Blacktown
City Council

18 September 2020

SSD 10399 – Clunies Ross Street, Prospect

ATTACHMENT A

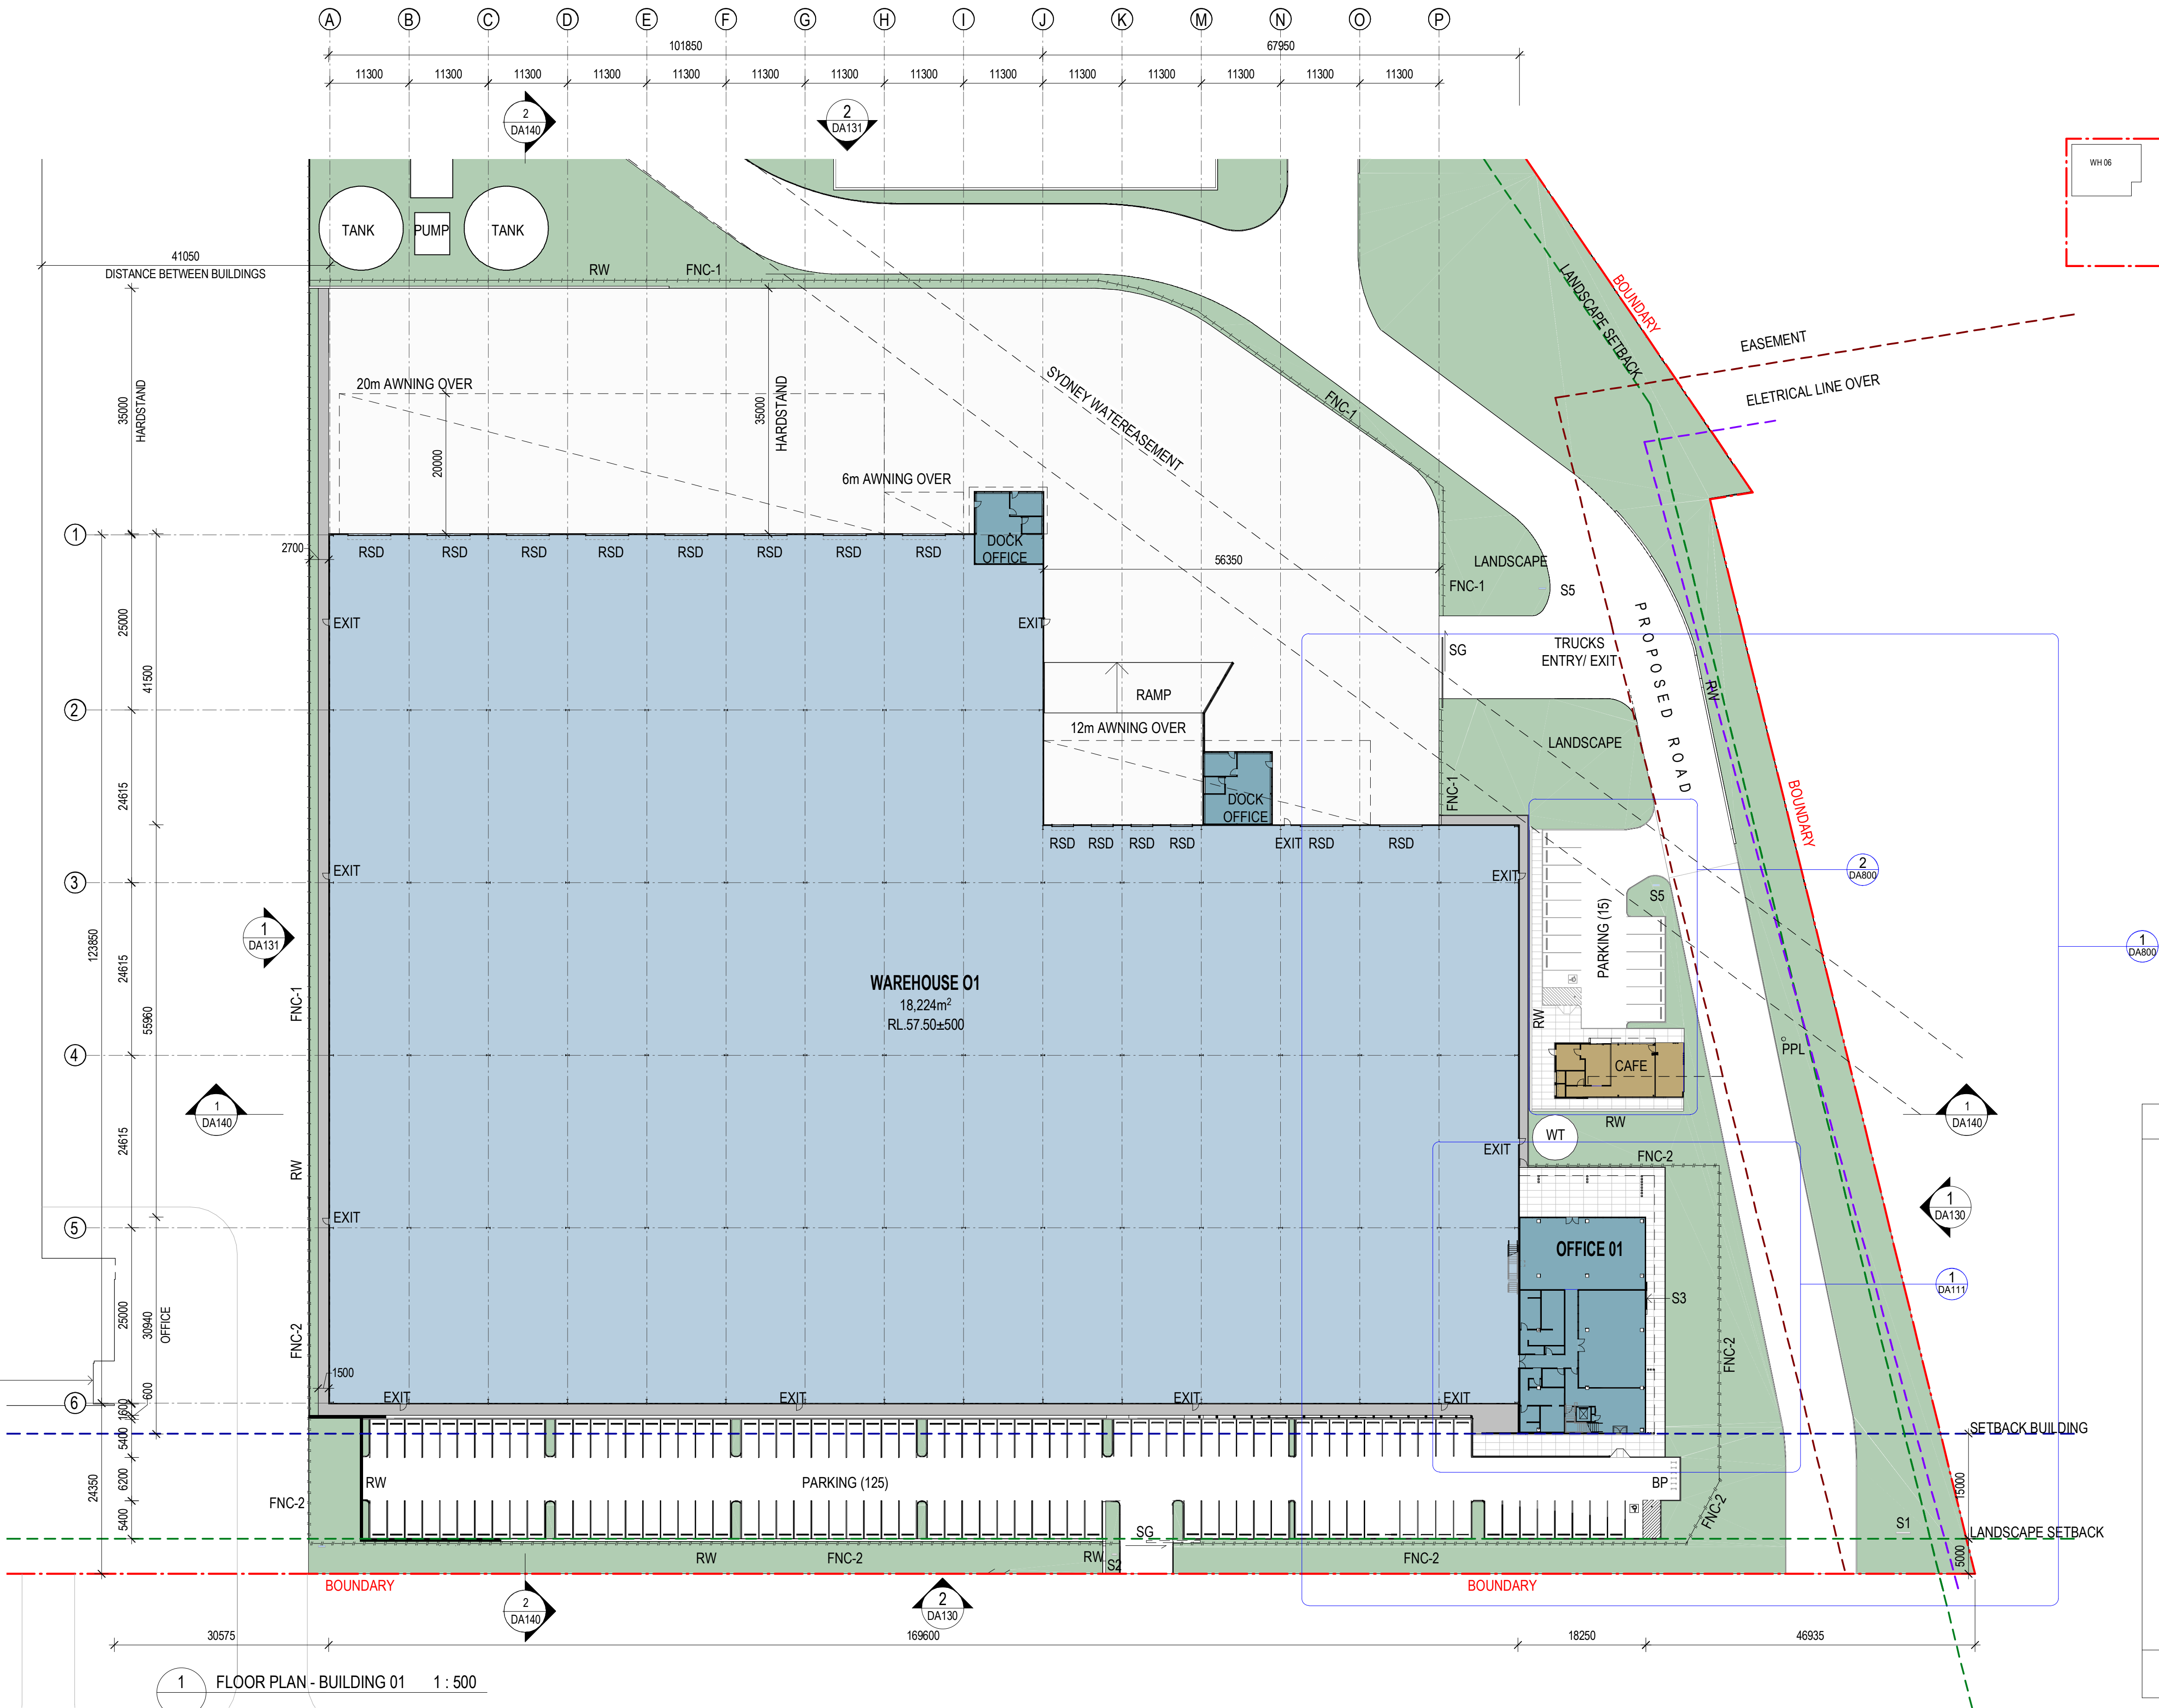
- The Draft DCP states the building setback to Clunies Ross Street is 20 metres with a minimum 3 metre landscaped setback, whilst the plan for warehouse 1 indicates the landscape setback is 5 metres.

This landscaping setback is considered insufficient and should be a minimum of 10 metres. No parking or structures should be permitted within the landscaped area.

- The draft DCP states the setback to Clunies Ross Street is 20 metres to the building and the first 3 metres is to be landscaped, however the LVIA prepared by Habit8 states the landscaping buffer zone to Clunies Ross Street is 5 metres. The submitted plans for Warehouse 1 indicate the landscape buffer as 5 metres.

1 BUILDING 1 NORTH ELEVATION 1 : 250

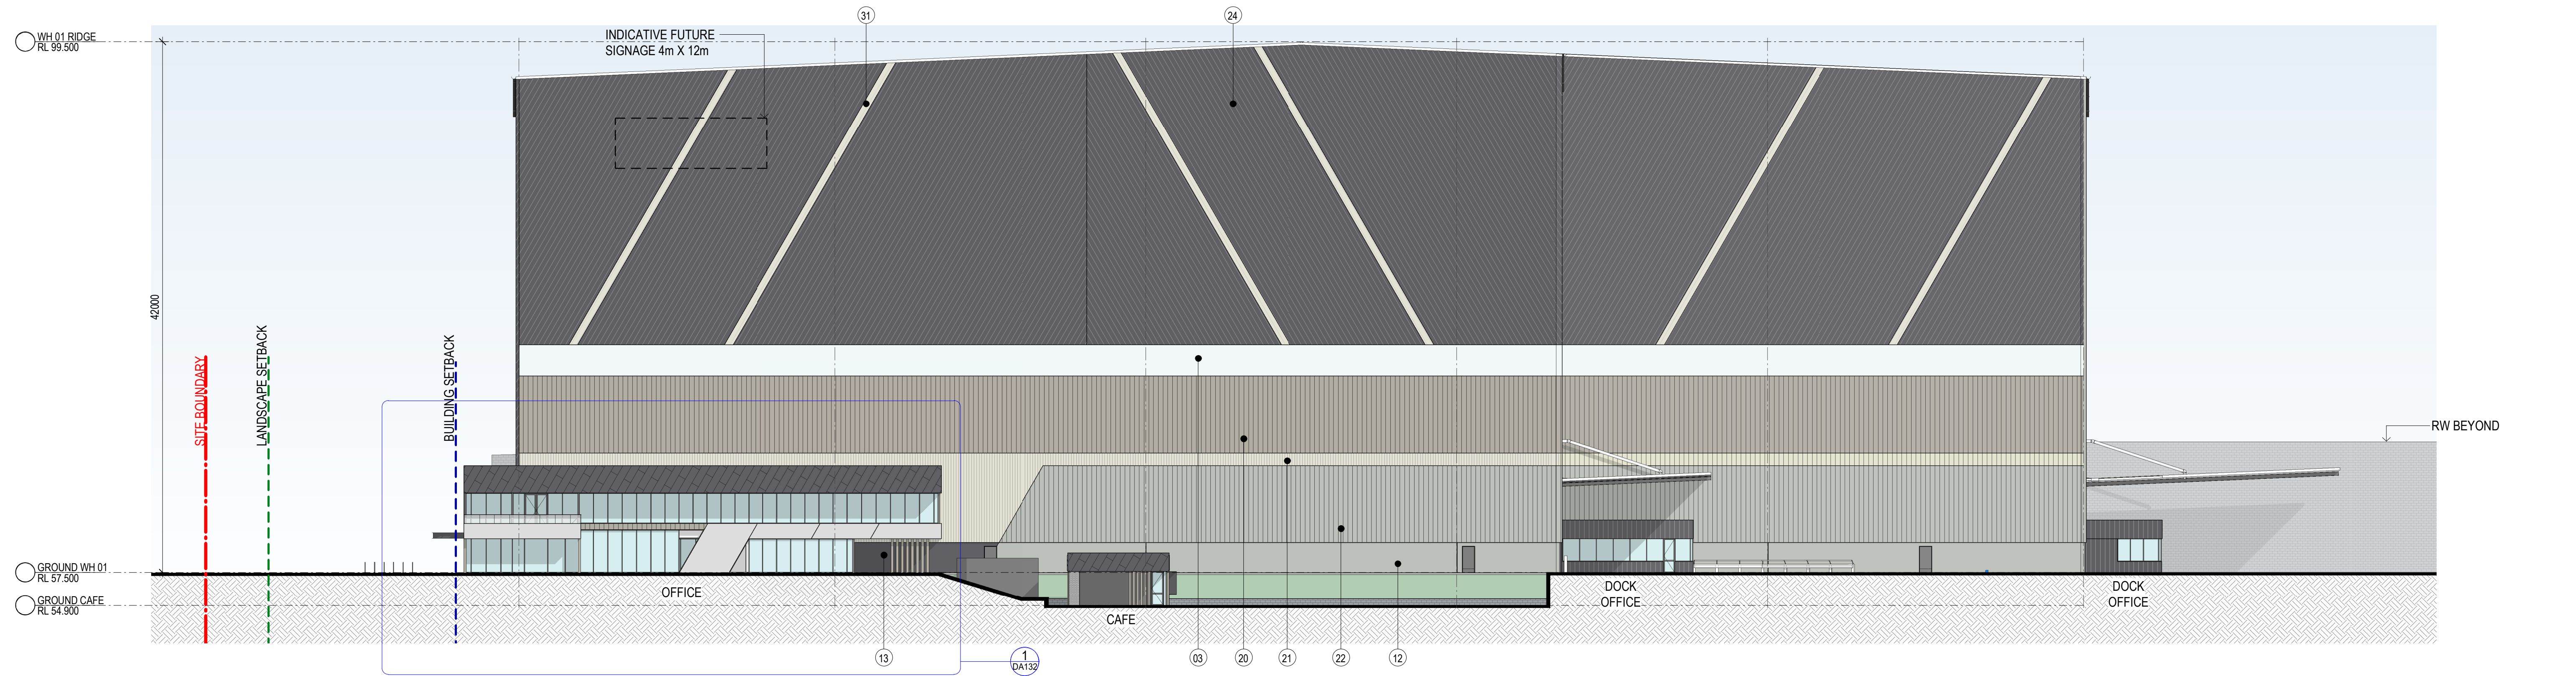
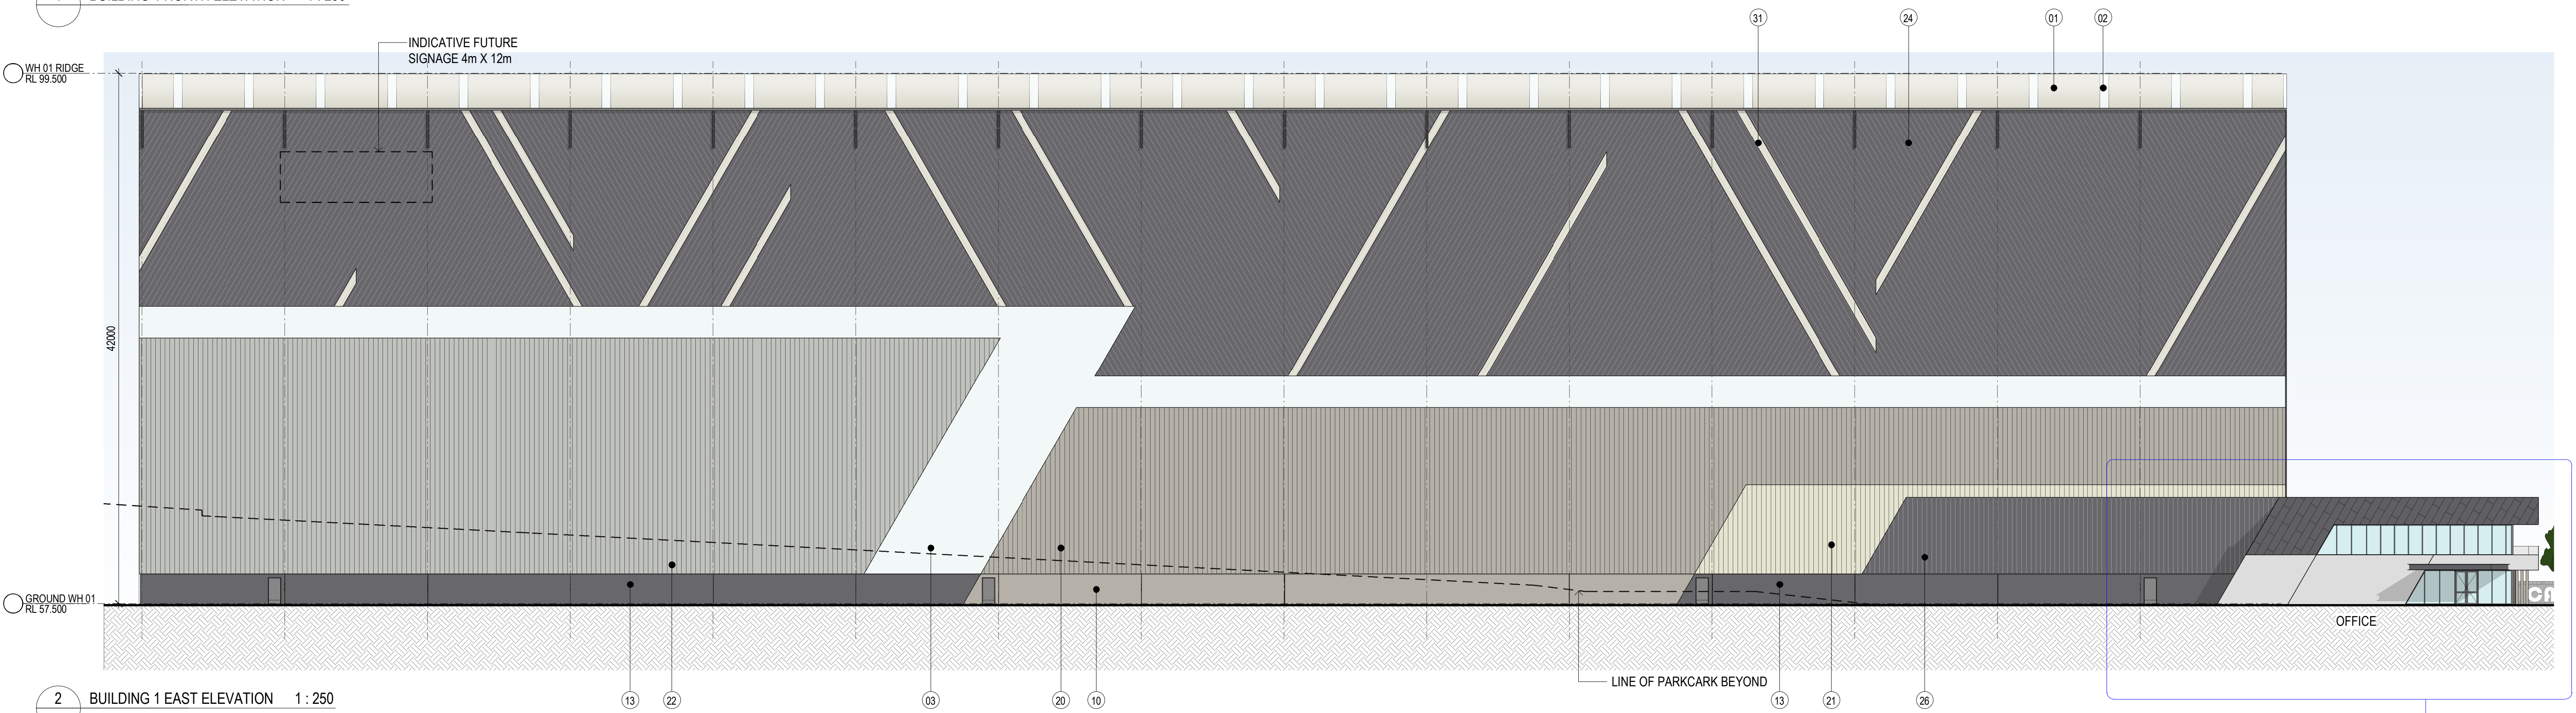
- To create building forms with appropriate scale and height, taking into consideration site topography.
- To ensure building heights do not adversely impact on the amenity of adjacent residential areas.
- Concerns are raised regarding the height of warehouse 1, which will be visually dominant when travelling south along Clunies Ross Street. The submitted Landscape and Visual Impact Assessment (LVIA) prepared by Habit8 states the Viewpoint H (Clunies Ross Street North (looking west) has a medium-high visual sensitivity, but is of a minor impact.

Consideration must be given to the reduction in height of warehouse 1 which is the first building seen when driving south along Clunies Ross Street towards the development site. In addition the height of the warehouse at 42 metres is considered to be excessive given its location within the wider development site as it's the gateway from Clunies Ross Street and the warehouses close proximity to the residential properties.
